Rezoning Transportation Analysis

Petition Number: 2025-048

Date	Description
5-28-25	First Review (IW/KC)
7-23-25	Second Review (IW/KC)

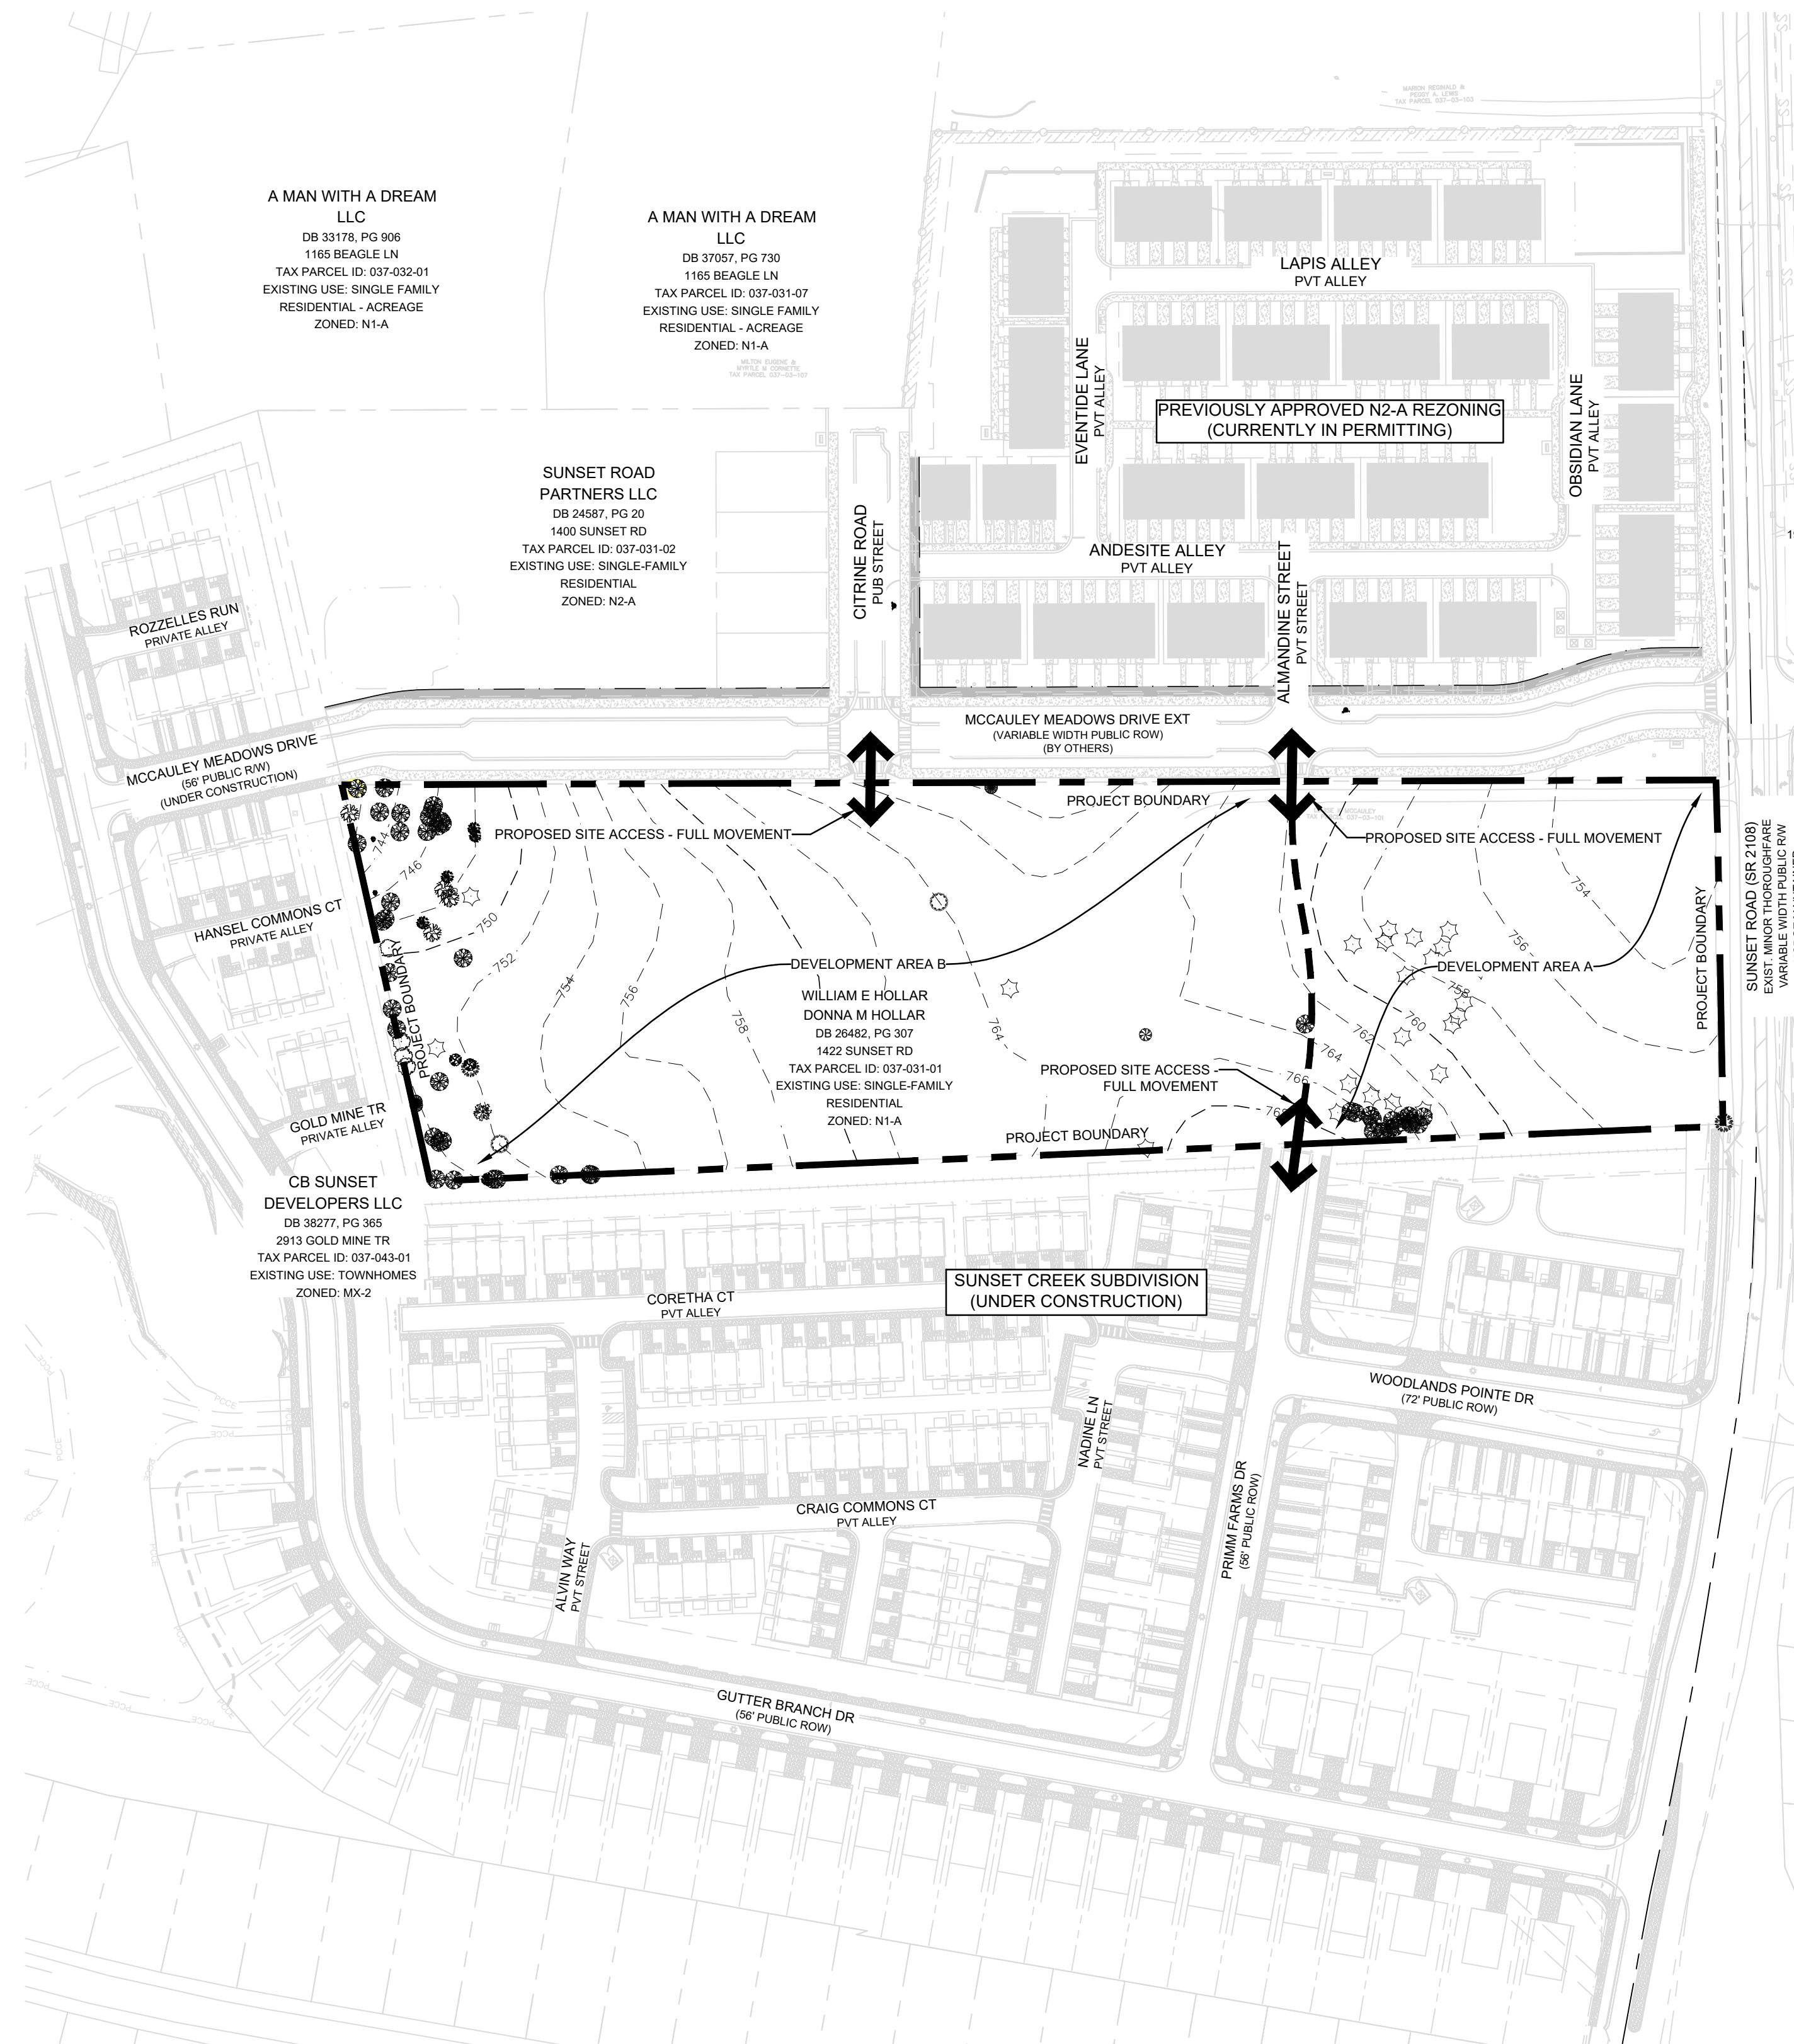
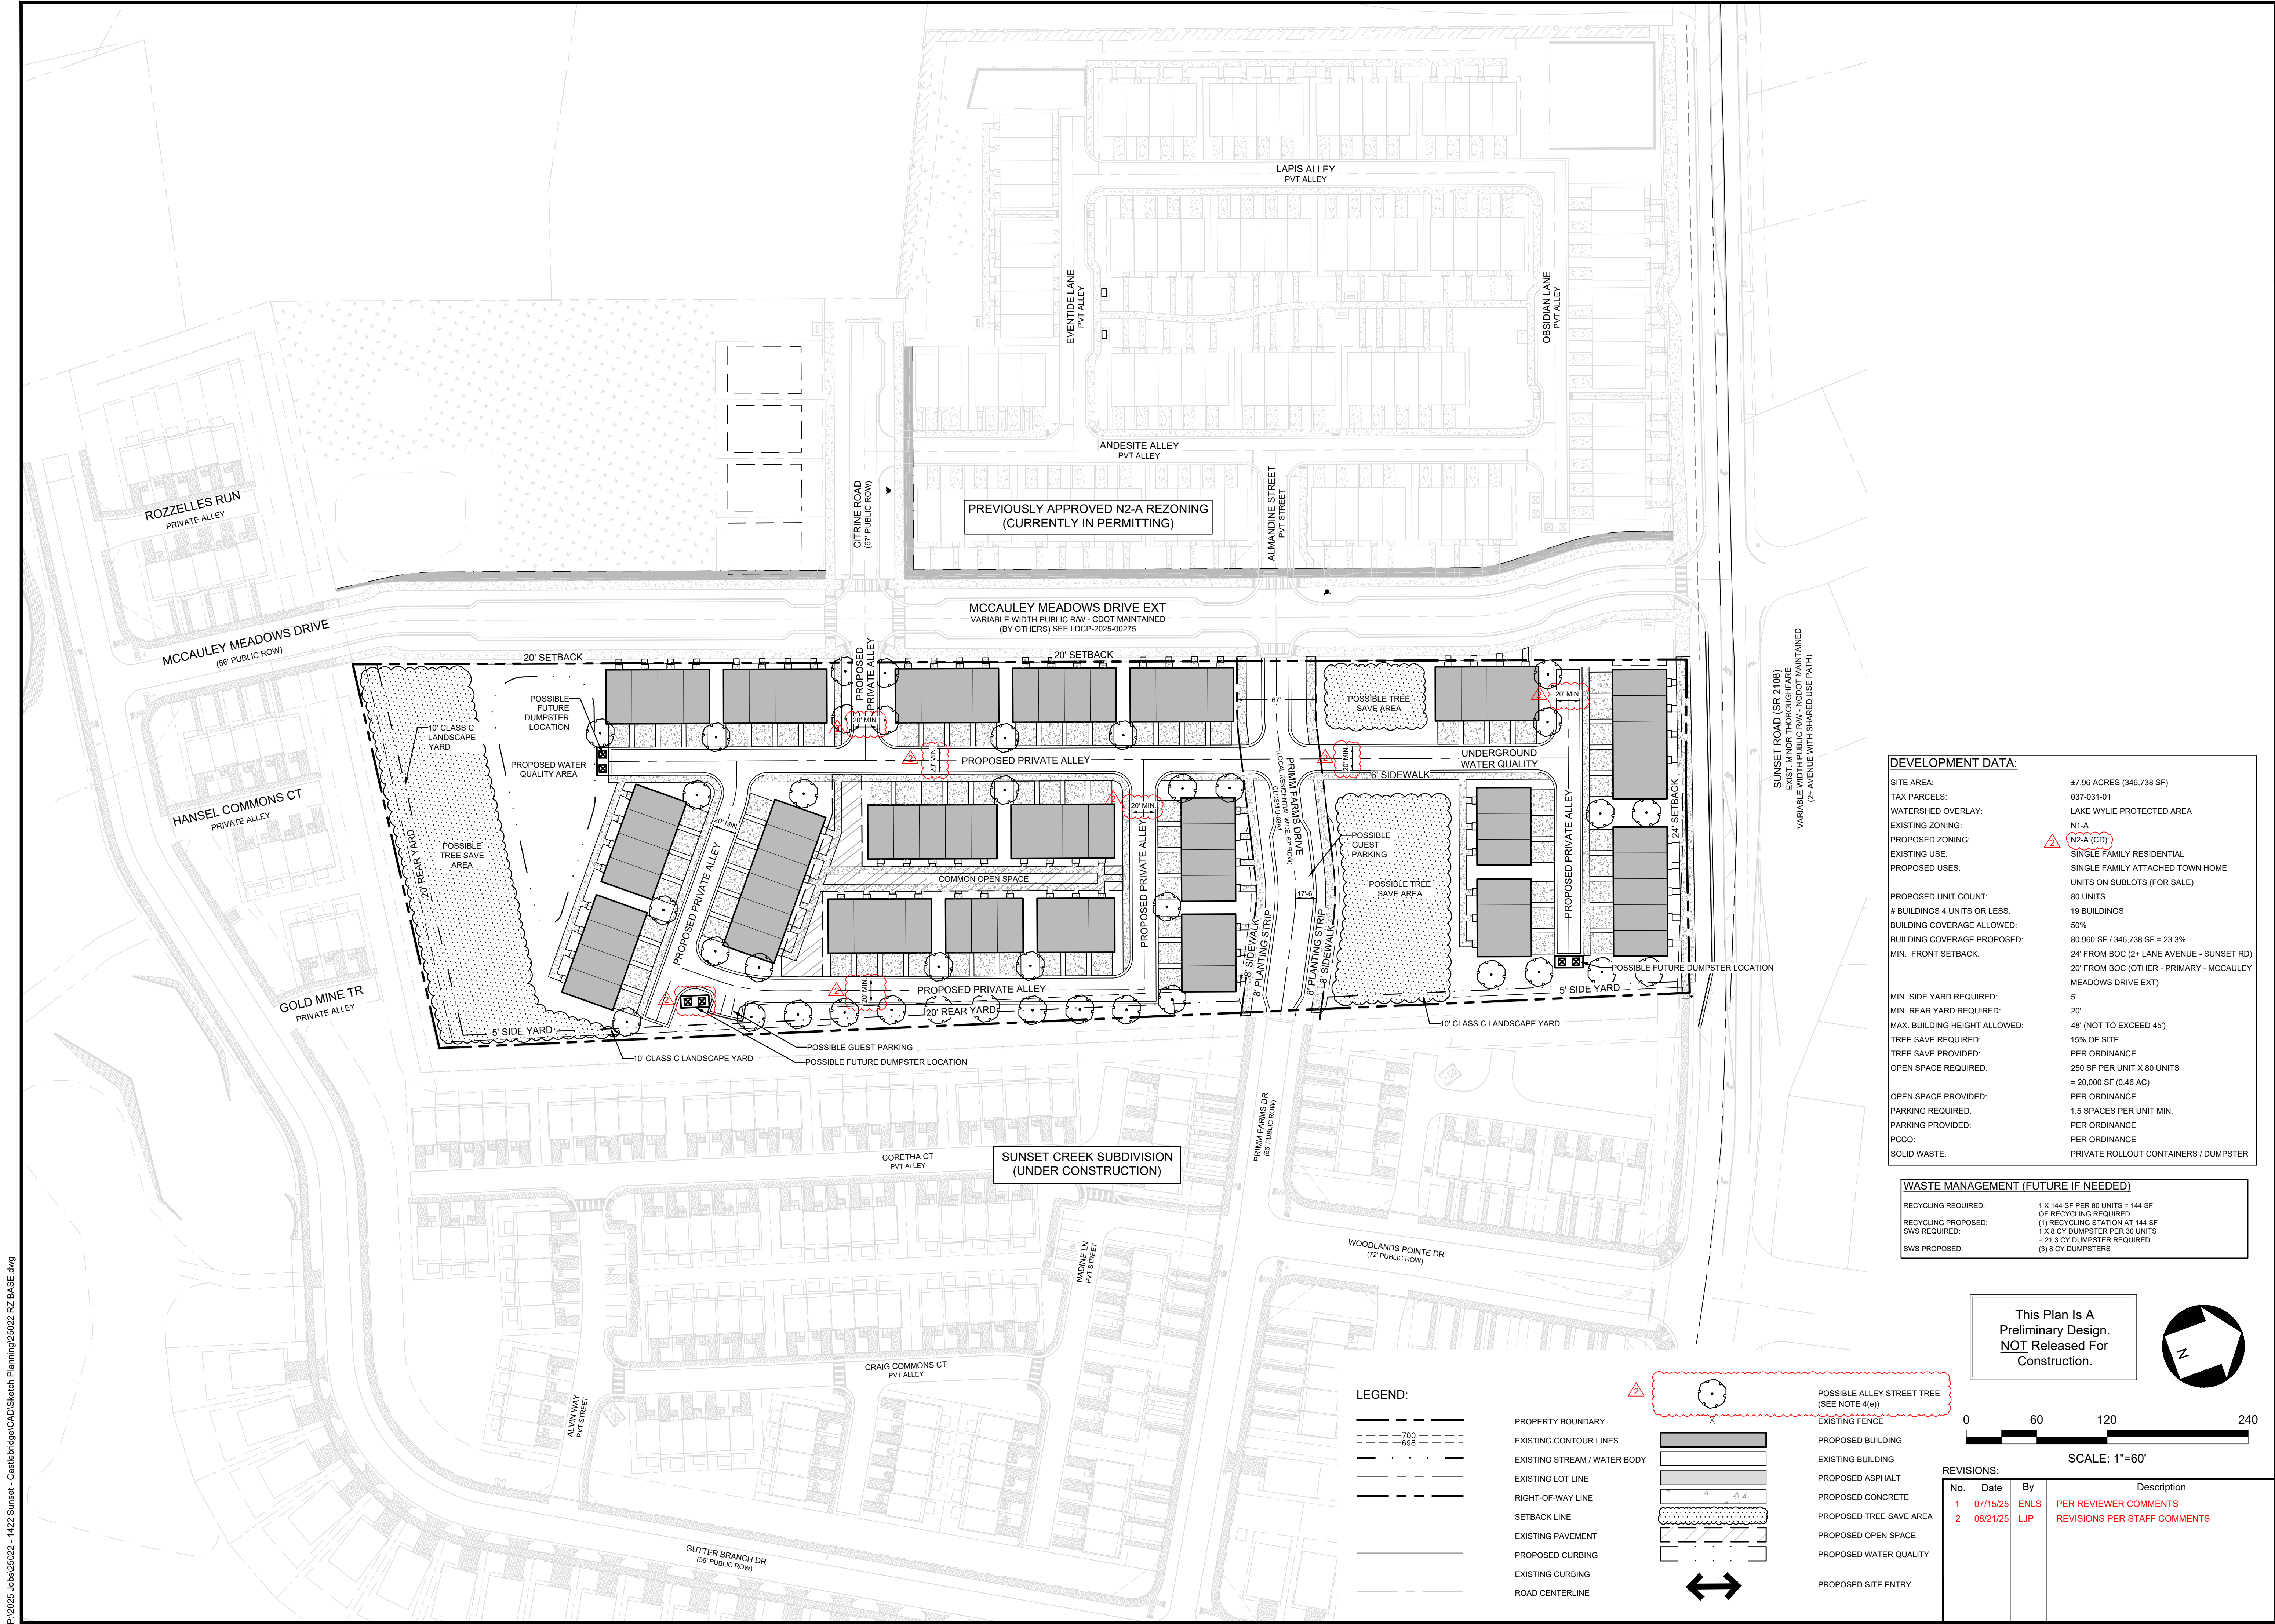
1. **Outstanding Comment from 5/28/25: Curbline:**

- a. **Sunset Road:** Location of future curb and gutter is to be installed 19' from centerline.

Label and dimension the curb and gutter from the centerline for each road on the site plan.

- b. **McCauley Meadows Drive:** Location of future curb and gutter is to be installed 17.5' from centerline.

Label and dimension the curb and gutter from the centerline for each road on the site plan.

- c. **Proposed Public Street:** Location of future curb and gutter is to be installed 17.5' from centerline.

Label and dimension the curb and gutter from the centerline for each road on the site plan.

3. **Outstanding Comment from 5/28/25:** Revise site plan and conditional note(s) to commit to dedicate 33.5' right-of-way from the road centerline along McCauley Meadows Drive and Proposed Public Street. The site plan shall label and dimension the right-of-way from the road centerline.

Clarification: McCauley Drive should show what the future right of way is to be. Label and dimension.
